November 29, 2023
Project No. T-8718

Subject: Response to City of Mercer Island Comments
3036 – 67th Avenue SE
Mercer Island, Washington

TG-01

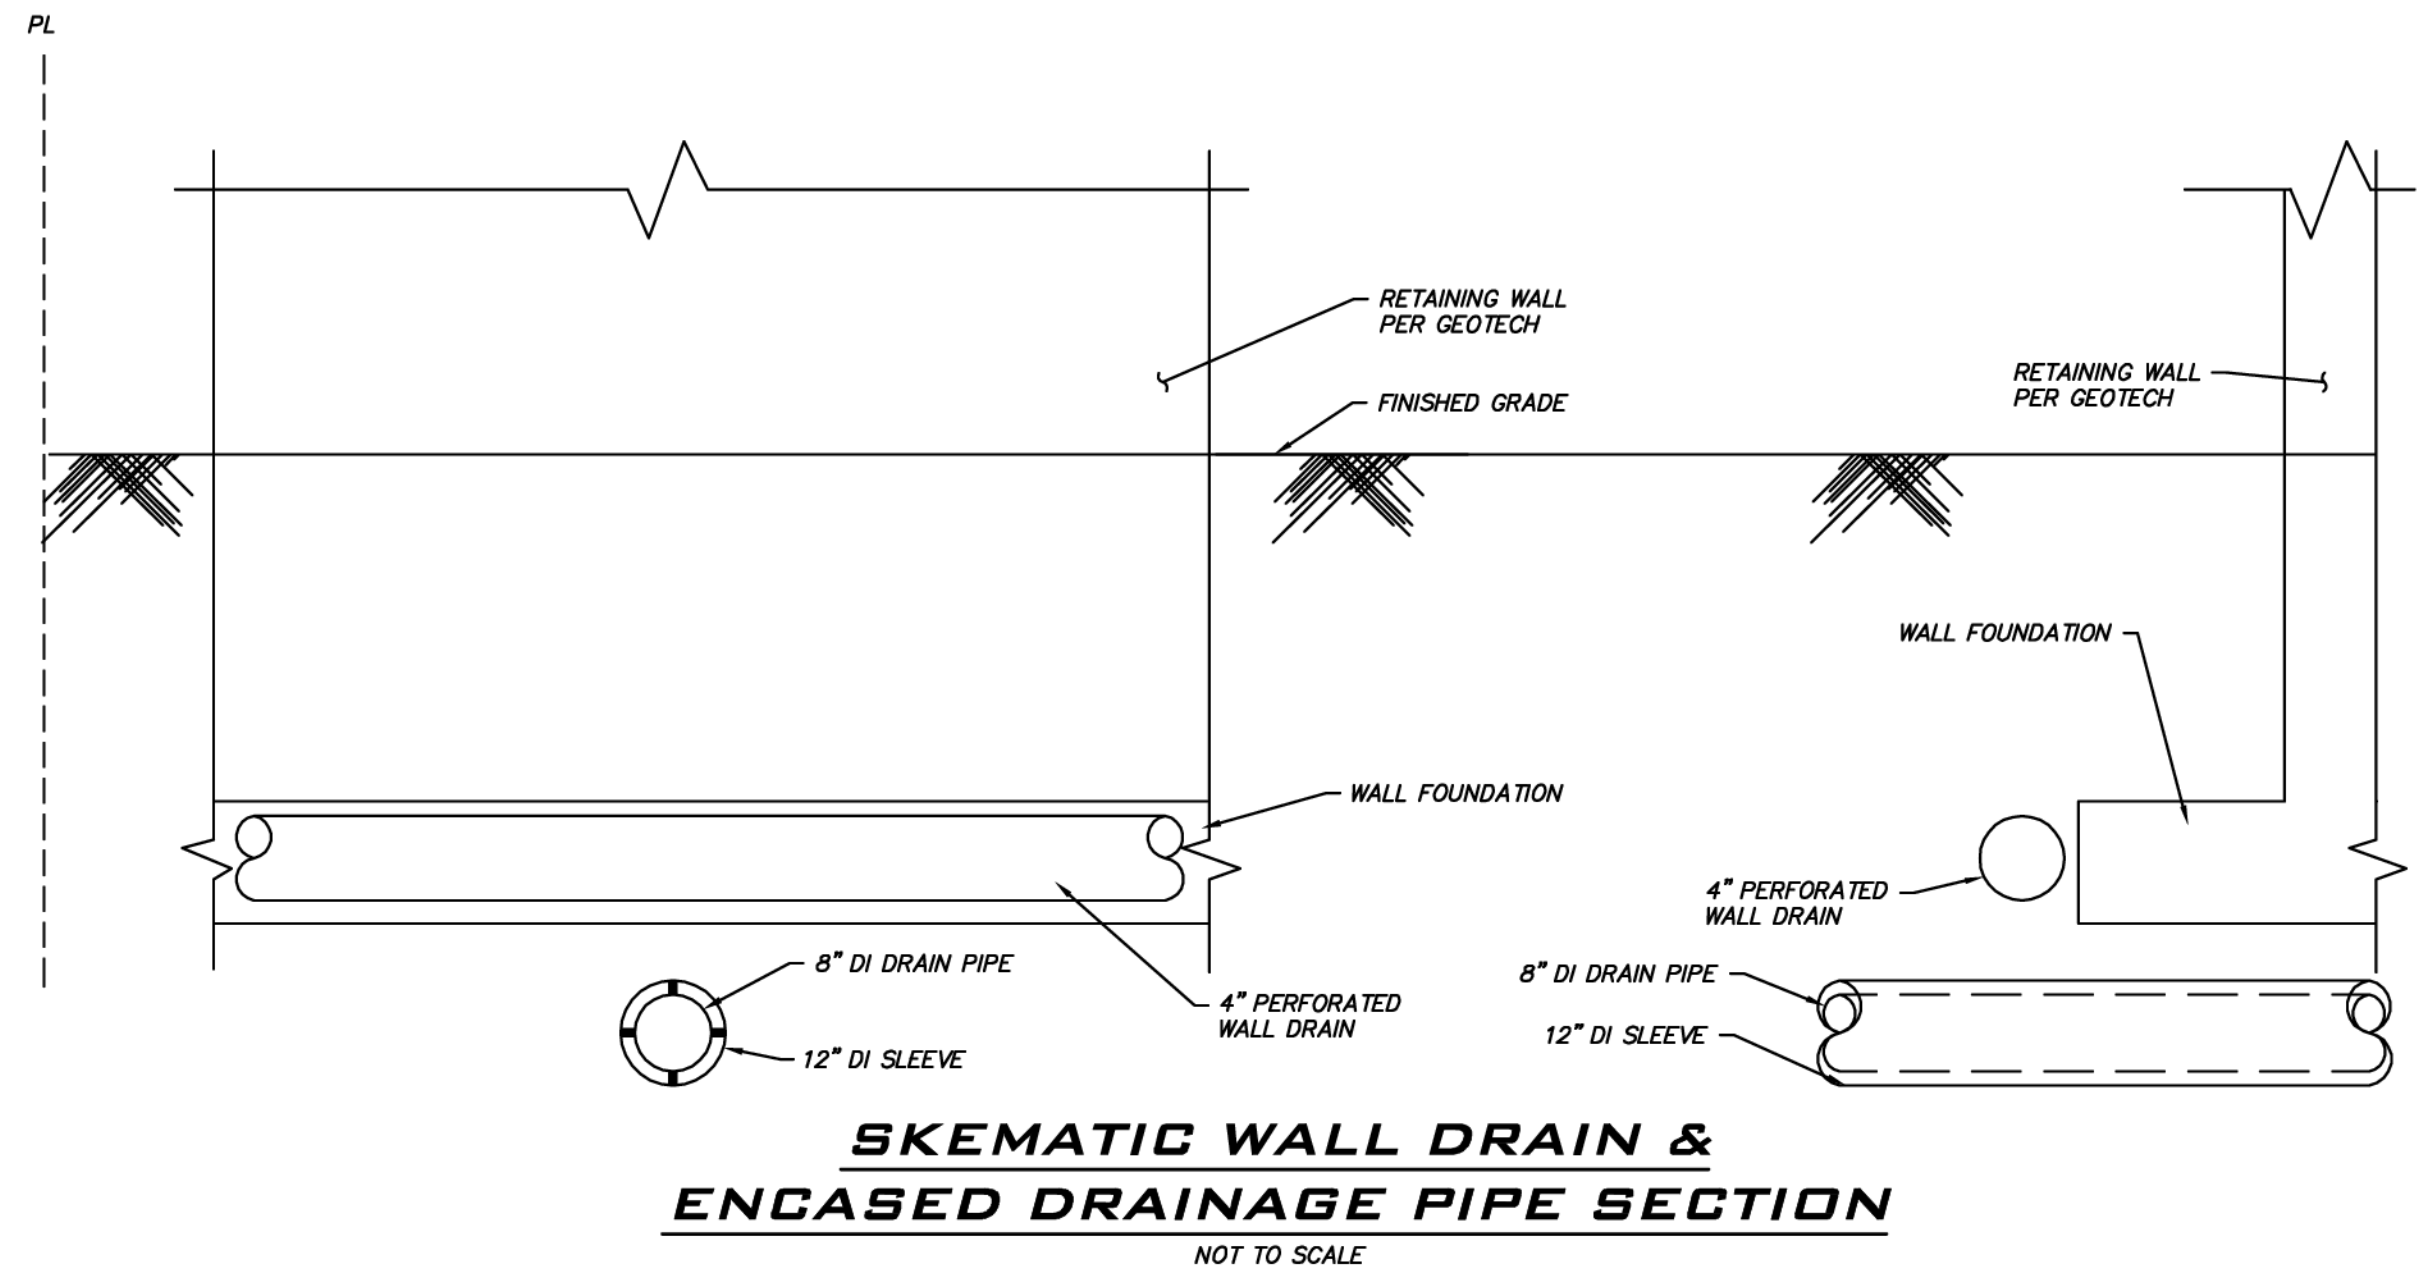
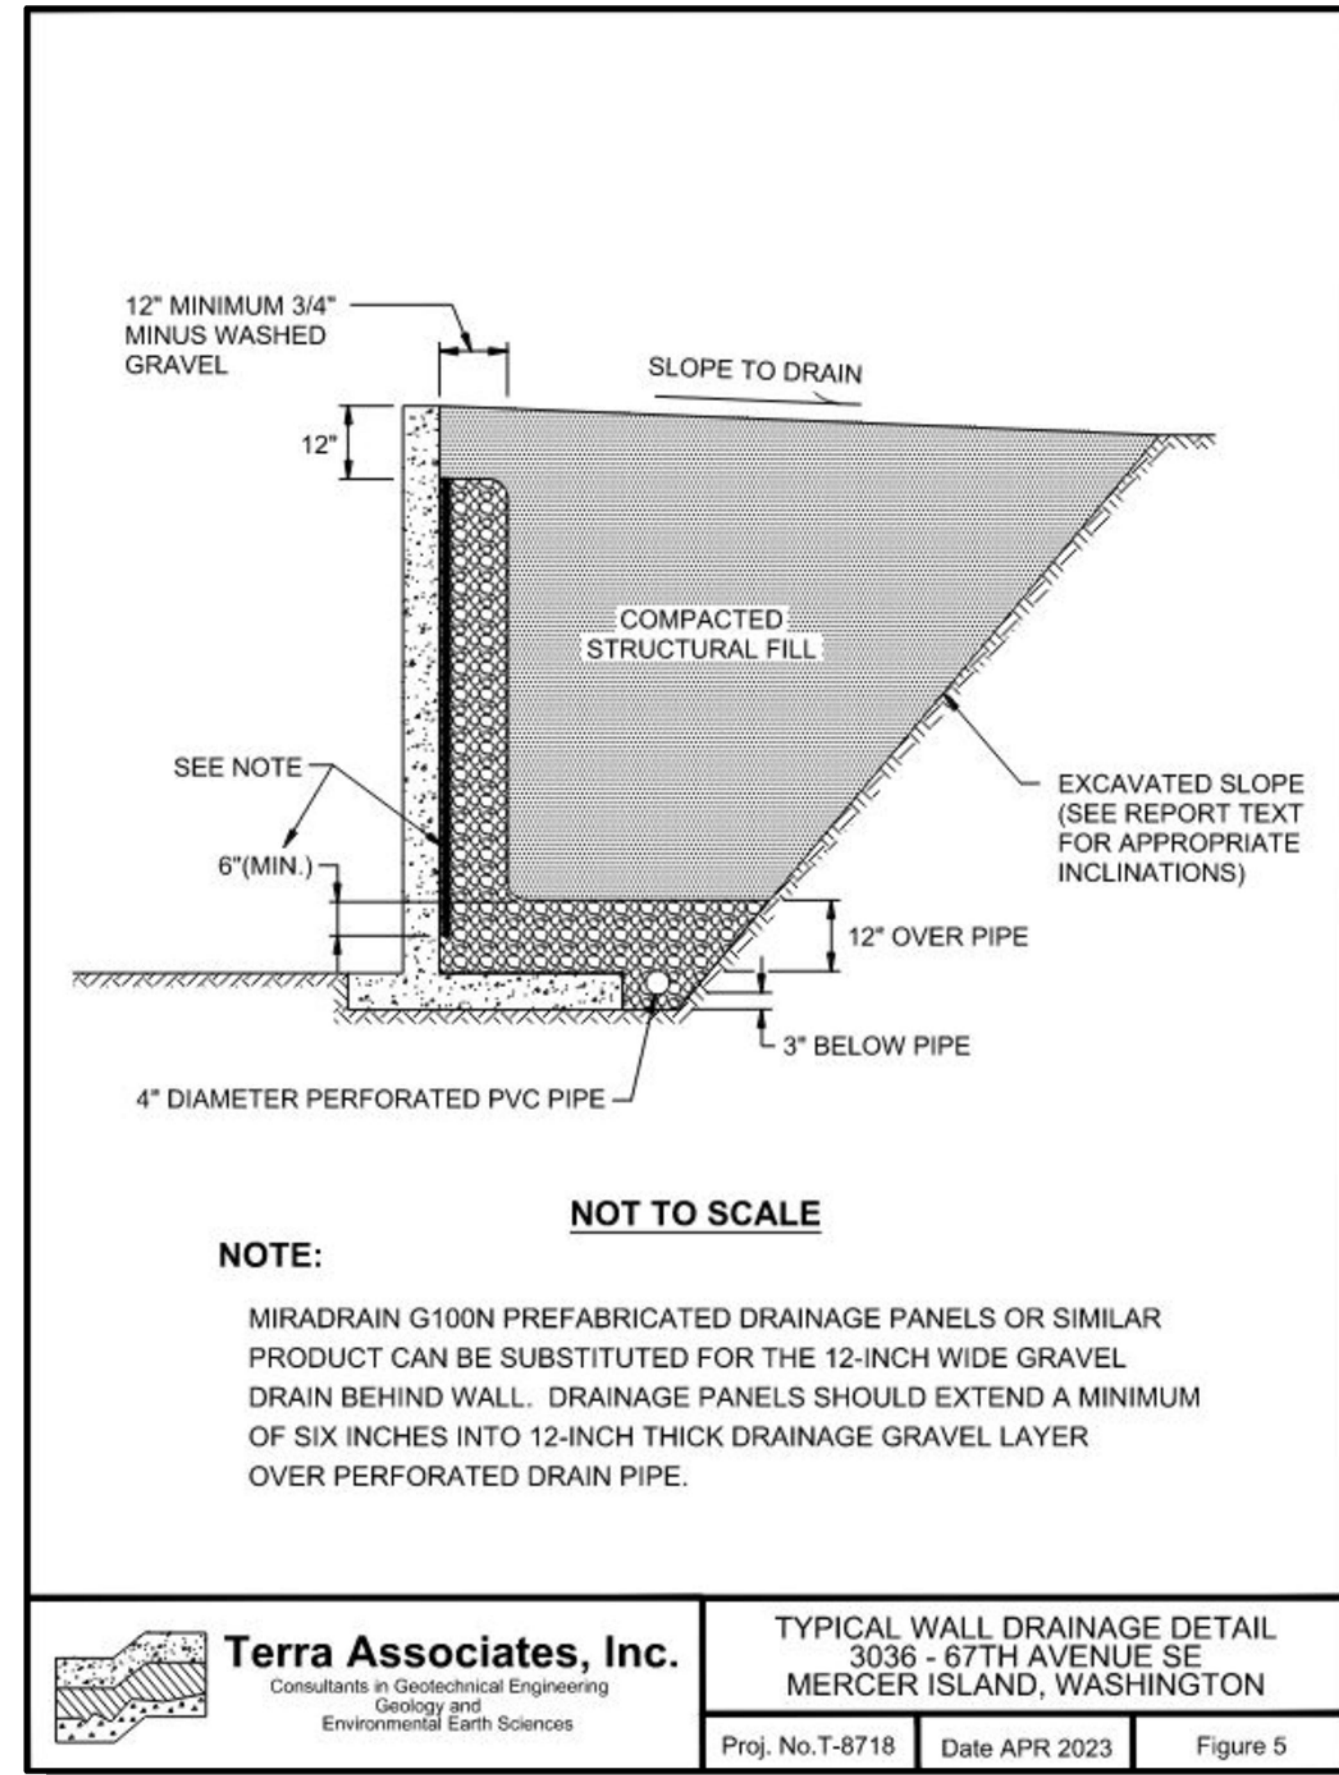
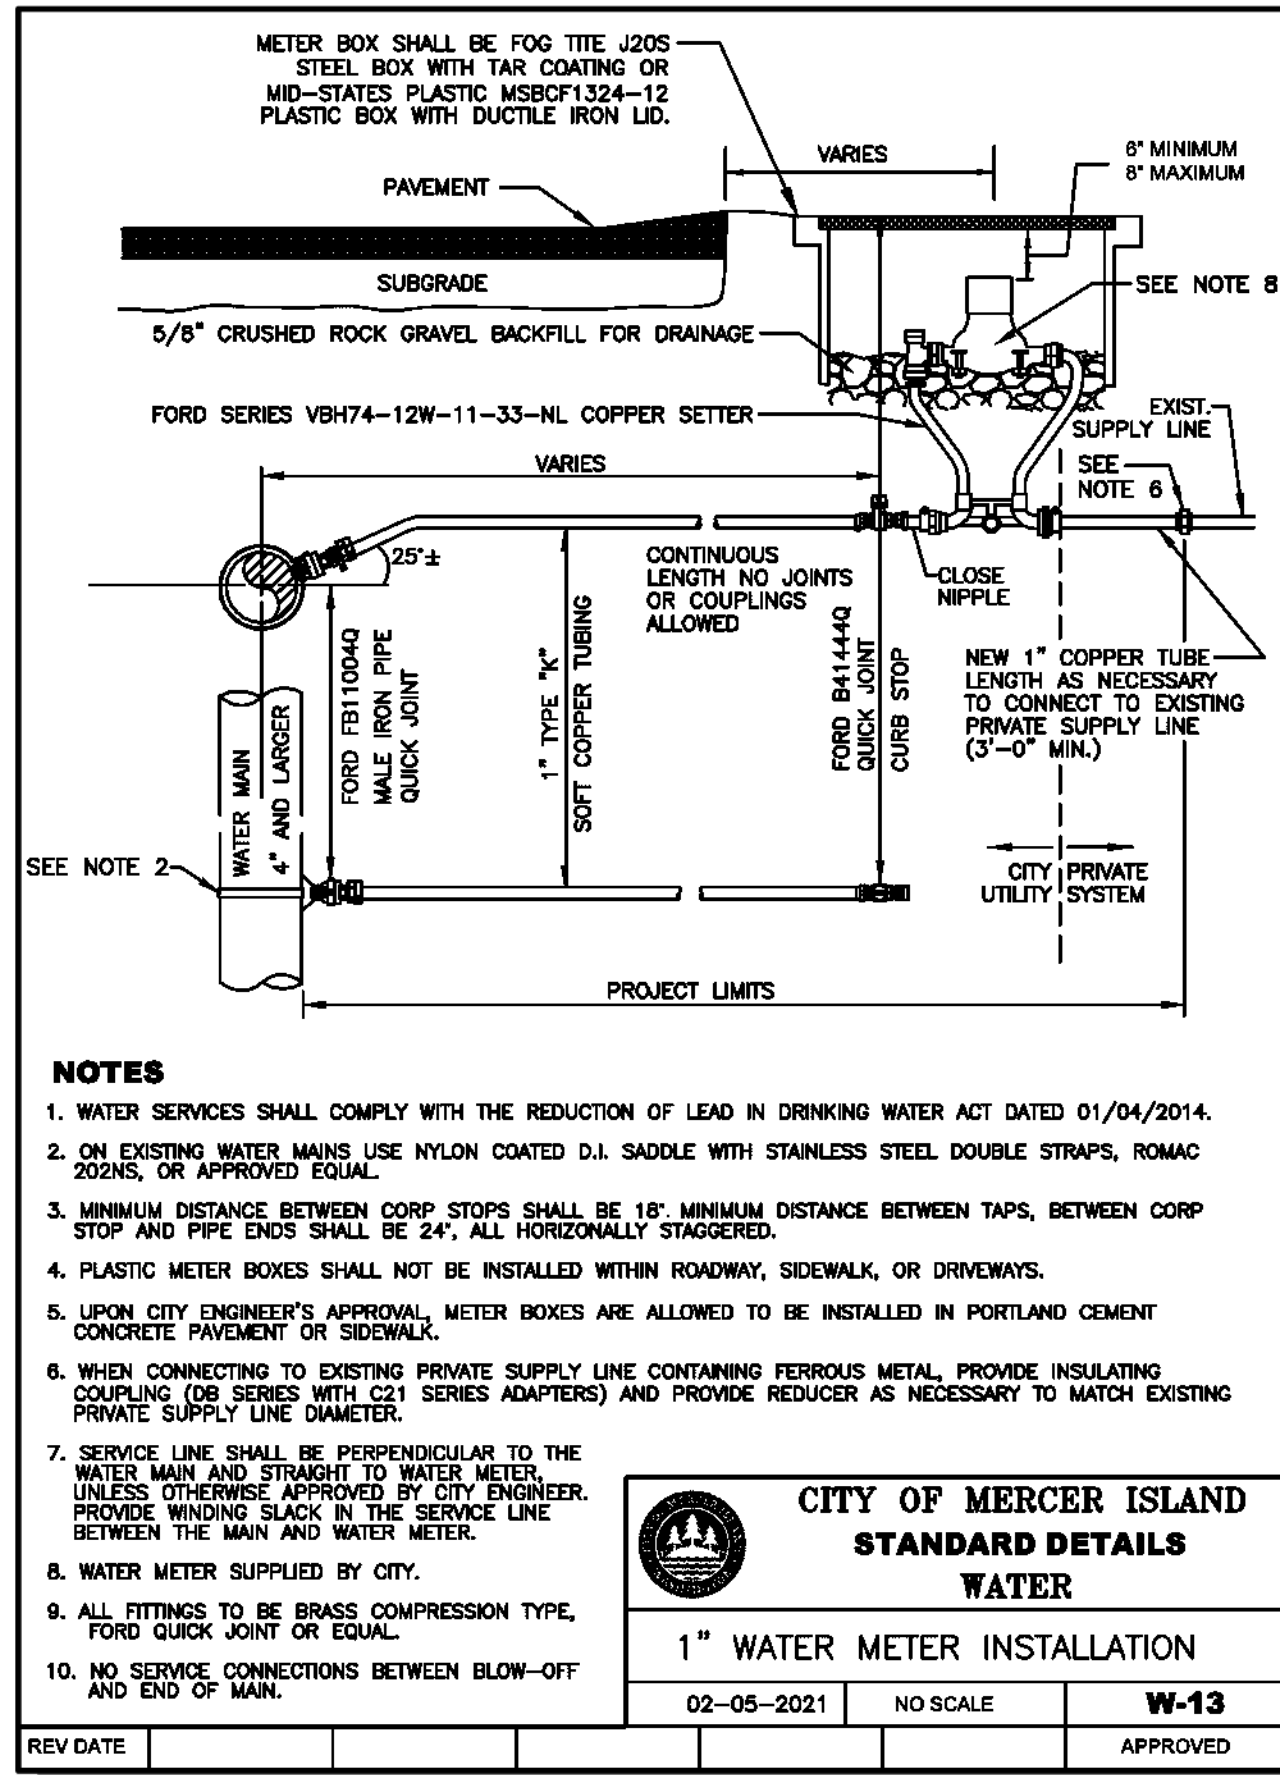
With the SUB5 plan set submission, please provide review letter from geotechnical engineer of record and updated statement of risk.

As requested, we have reviewed Sheets S-0.0 and S-0.1 prepared by Mulhern+Kulp dated November 27, 2023, Sheets A1.1, A2, A8, and D1 prepared by Architectural Innovations, P.S, dated November 27, 2023, and Sheets SP-01, TG-01, and DT-01 prepared by Atwell dated November 20, 2023. Based on our review, the project consists of developing the site with a new single-family residence, associated access, and utilities. The plans indicate the residence will be a three-story, wood-framed structure with an attached garage constructed at grade. An interceptor trench will be installed on the east side of the site with a bottom elevation of 95.70 feet.

Grading to achieve the bottom of footing elevation of 99.66 feet will require excavation depths of 10 to 13 feet below current site grades. Based on our review, there is sufficient room to complete the excavation using conventional excavation techniques with a 1.5:1 (Horizontal: Vertical) temporary excavation slope.
